# AMRC NW

## Planning design report

832-CPA-XX-XX-RP-A-9015

**Drawing No.**  
832-CPA-ZZ-03-DR-A-2103

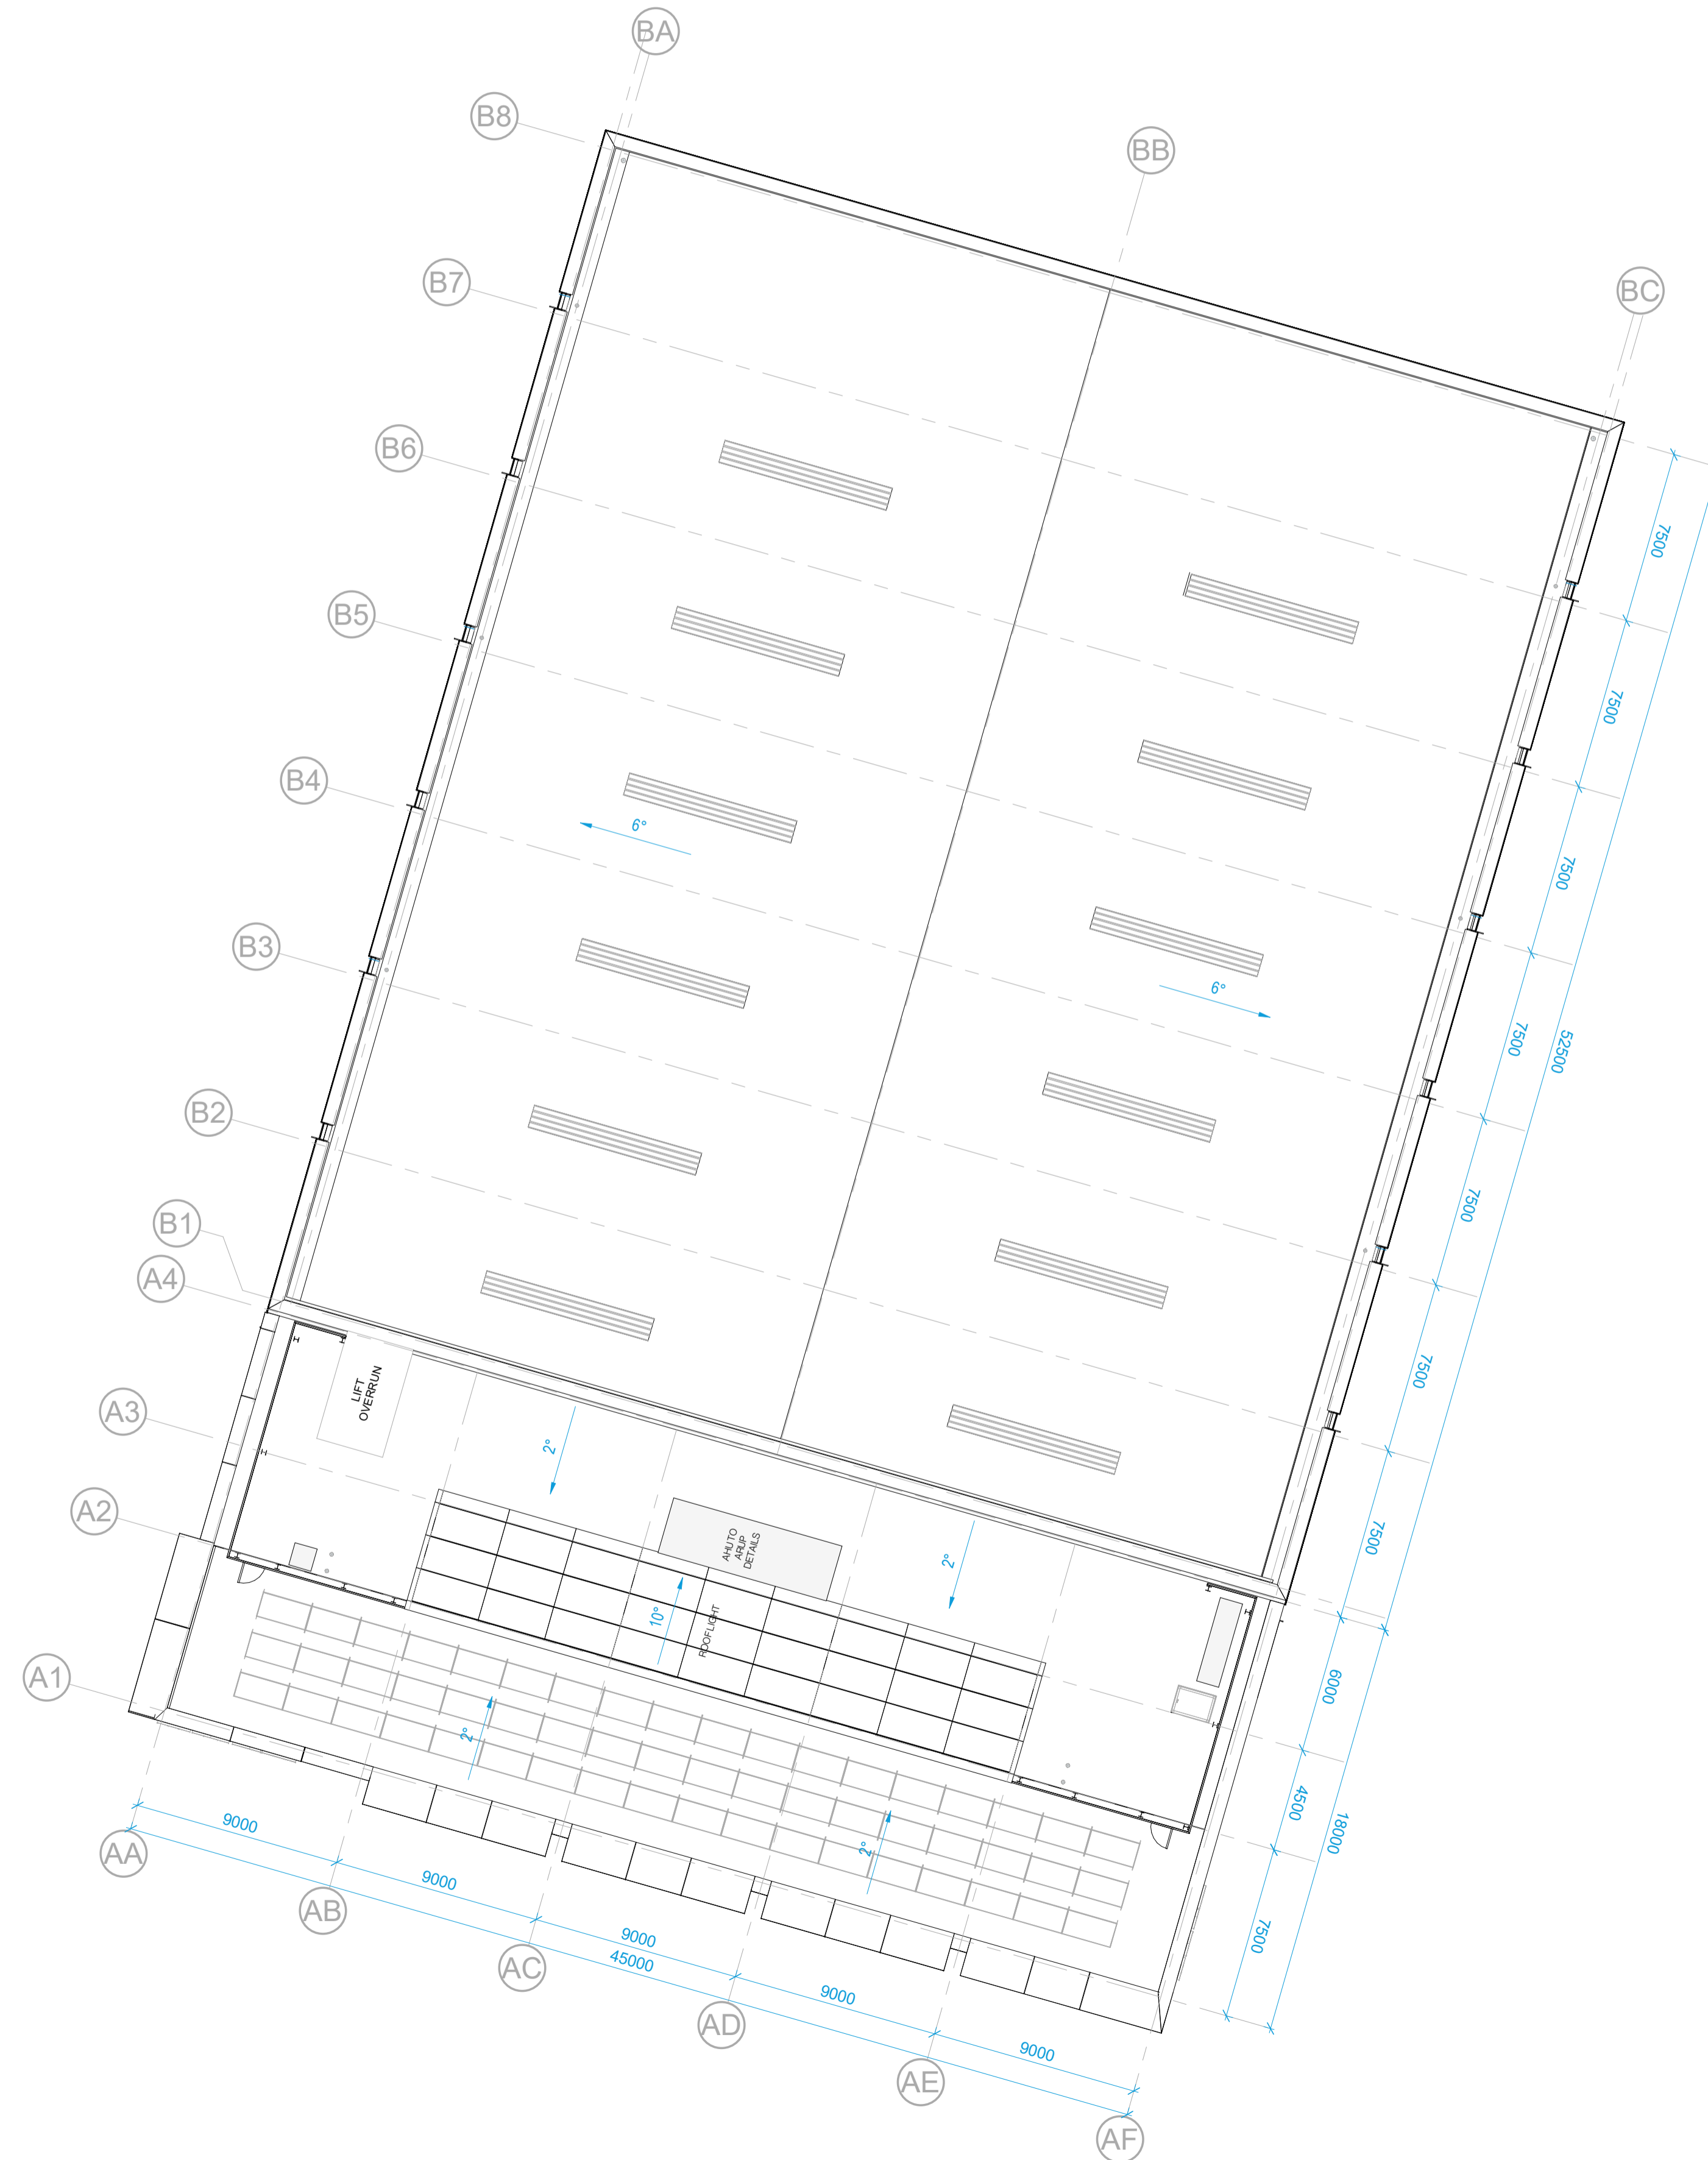
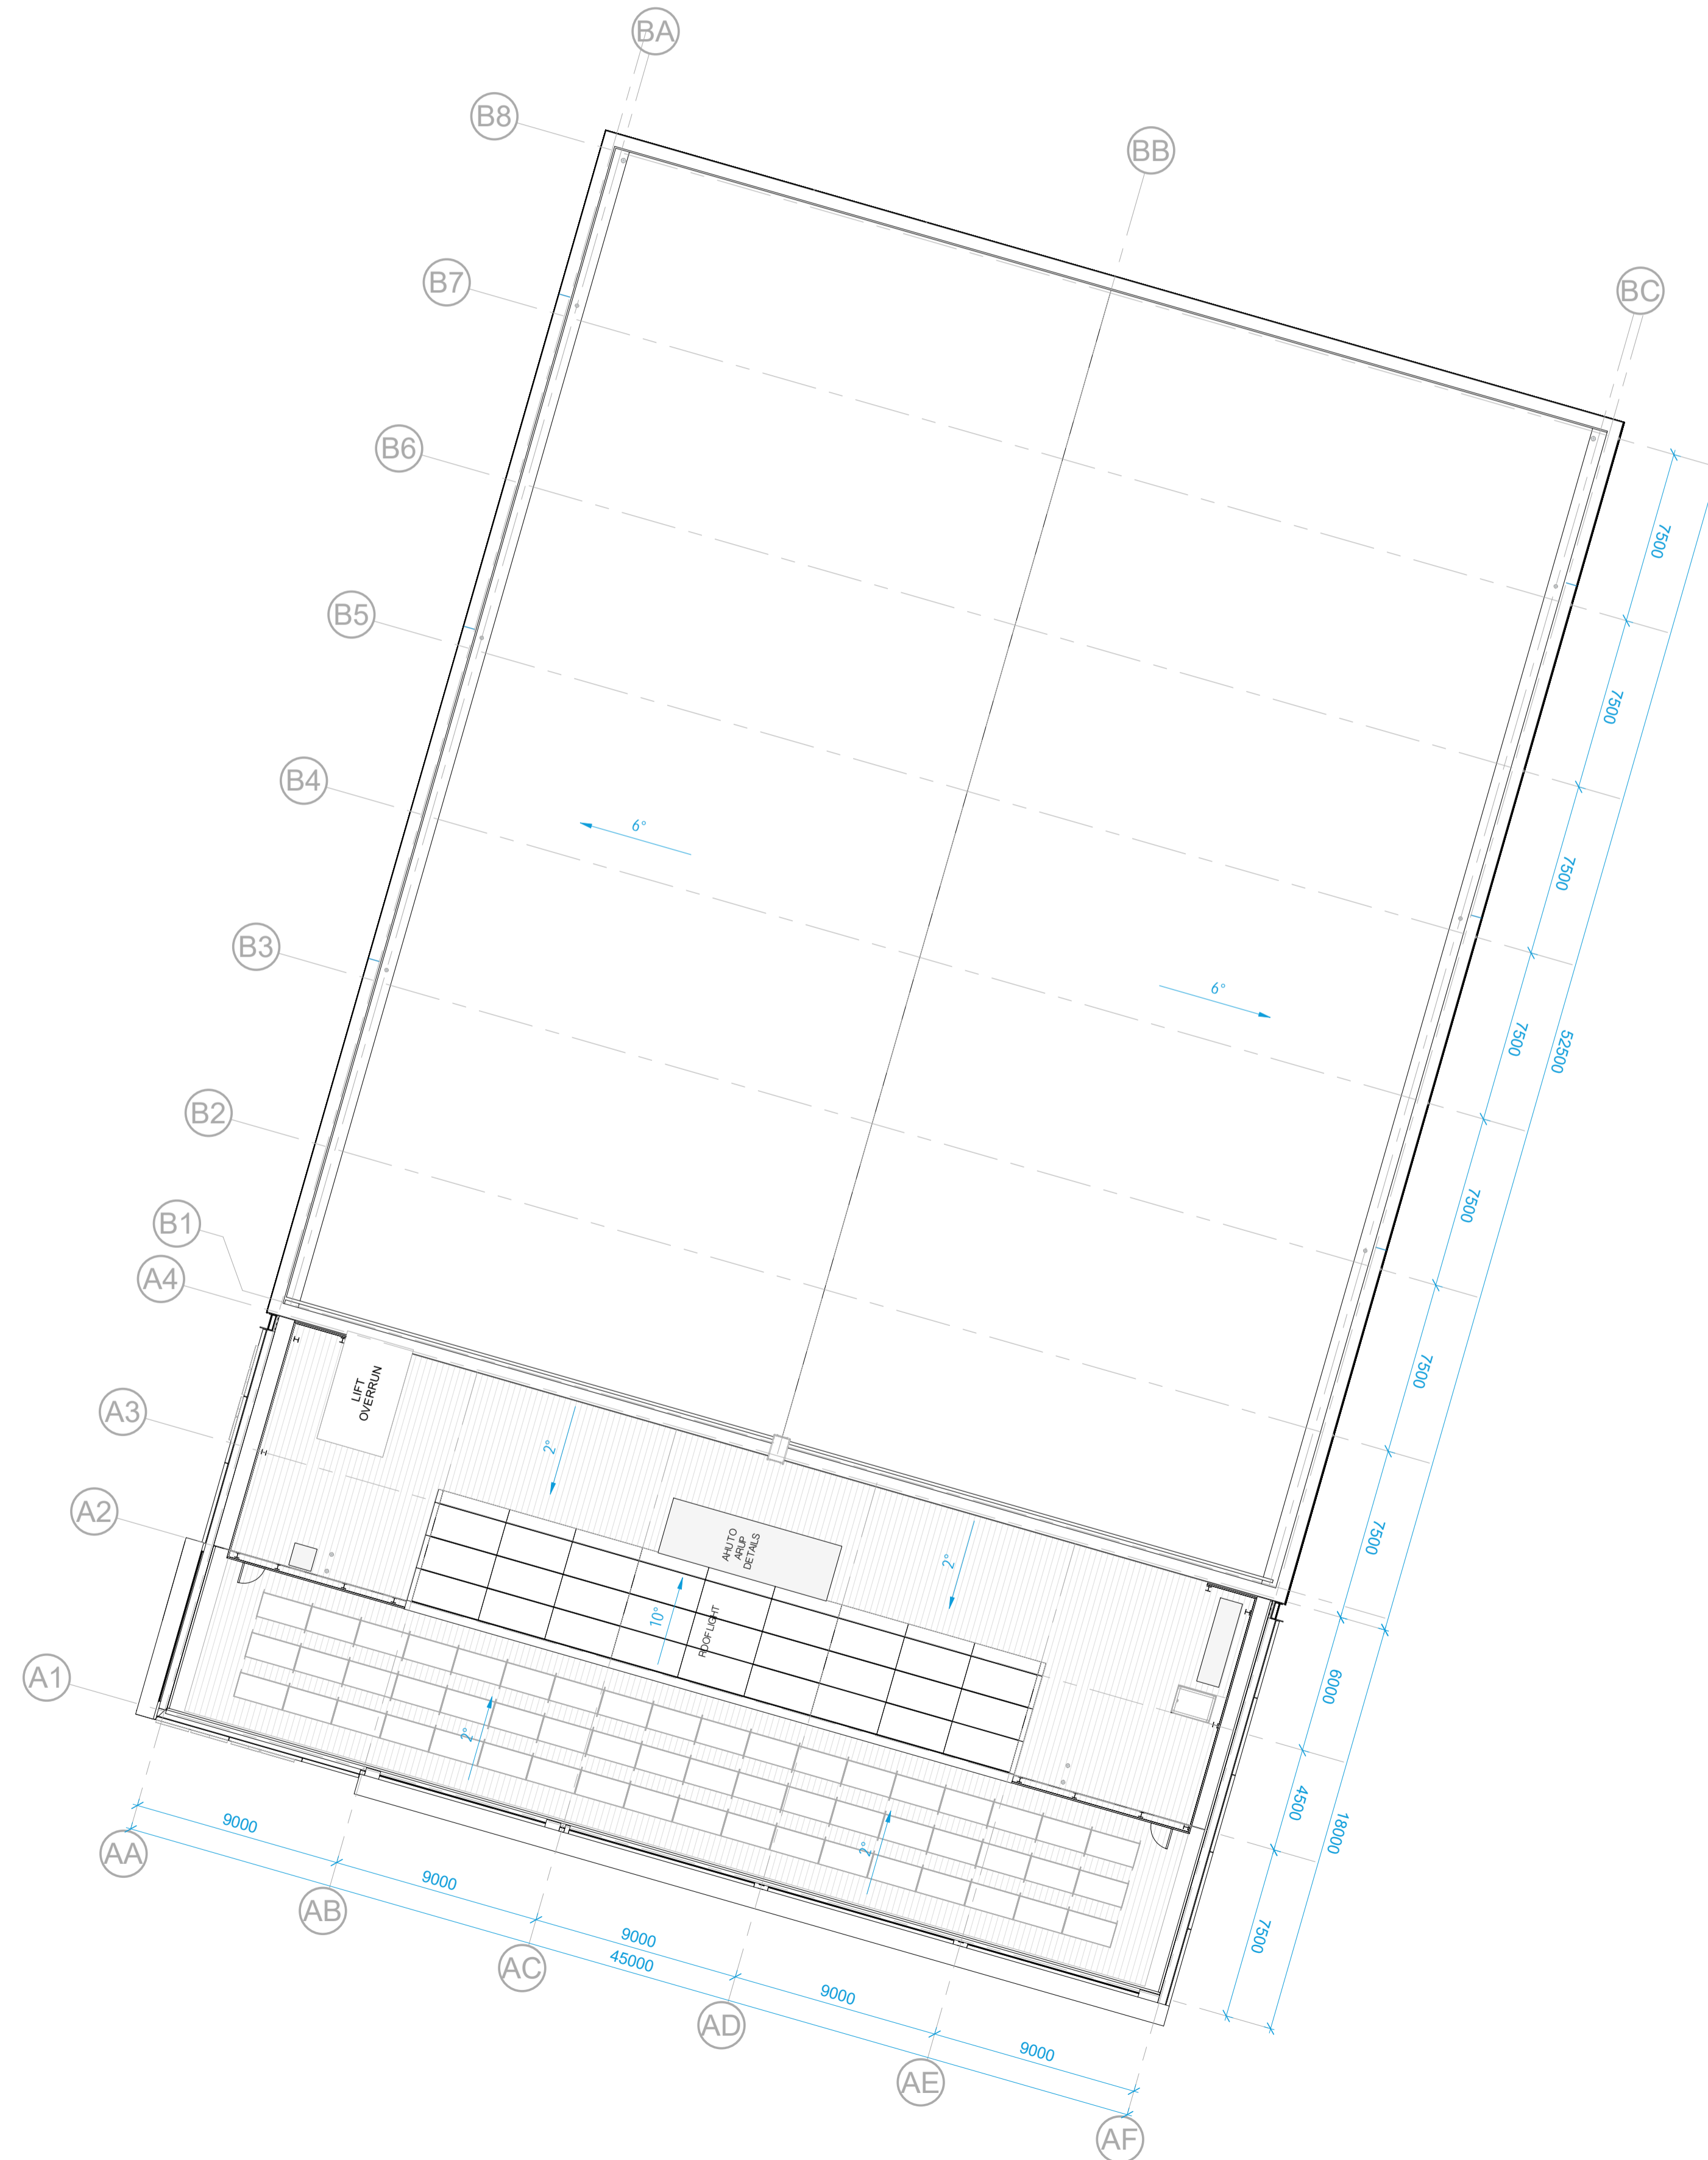
- 832-CPA-ZZ-03-DR-A-2103 - Rev A
  - Roof configuration retained
  - South elevation bays reduced and rationalised
  - Roof-lights omitted to workshop
- Black box proposed for controlled environment in workshop
